Attachment A 7664 MOD 1 Response to Submissions

Horsley Drive Business Park Stage 2
Section 4.55(2) Modification Application

Submitted to Department of Planning &
Environment
On behalf of Charter Hall

17 June 2020 | 2190880

Figure 1 Proposed Plan of Subdivision

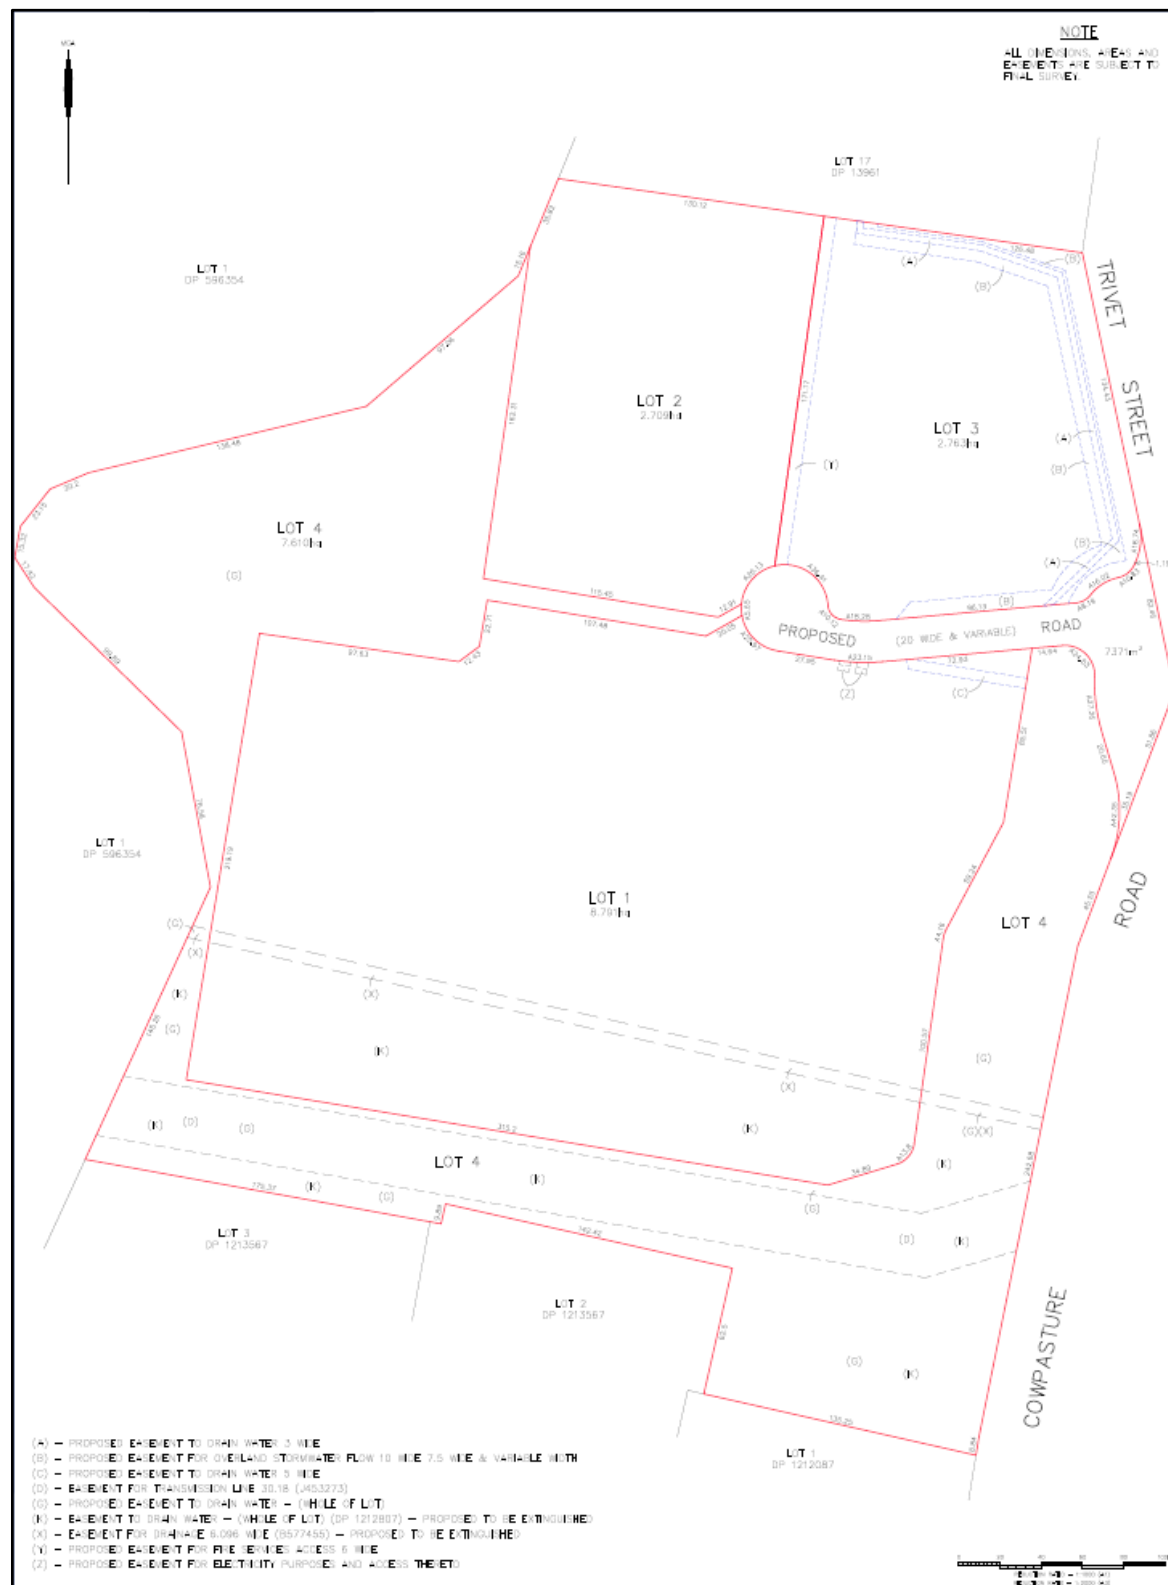
Site Layout	
An amended site plan which clearly illustrates for example existing lot boundaries, topographic contours, lot sizes, building envelopes, easements, existing infrastructure.	- An amended site plan is attached at Appendix B that correctly identifies all relevant lots that formed the site area under the Concept Approval for SSD 7664. - The lot boundaries, building envelopes and existing infrastructure are all clearly shown on the Overall Site Plan (DA02). - To ensure the retention of clarity on the site plan, the topographic contours are detailed within the civil drawings (DA20) prepared by Costin Roe and submitted with the Modification Application.
Confirm if lot consolidation is being sought under SSD 7664 MOD 1. If so, the amended site plan should reflect this and a plan of consolidation, provided.	- Lot consolidation is being sought under SSDA 7664 & SSD 7664 MOD 1. - Please refer to the subdivision plan submitted with the Modification Application. - The overall site plan (DA02) prepared by Leffler Simes Architects has been amended to reflect this consolidation (Appendix B).
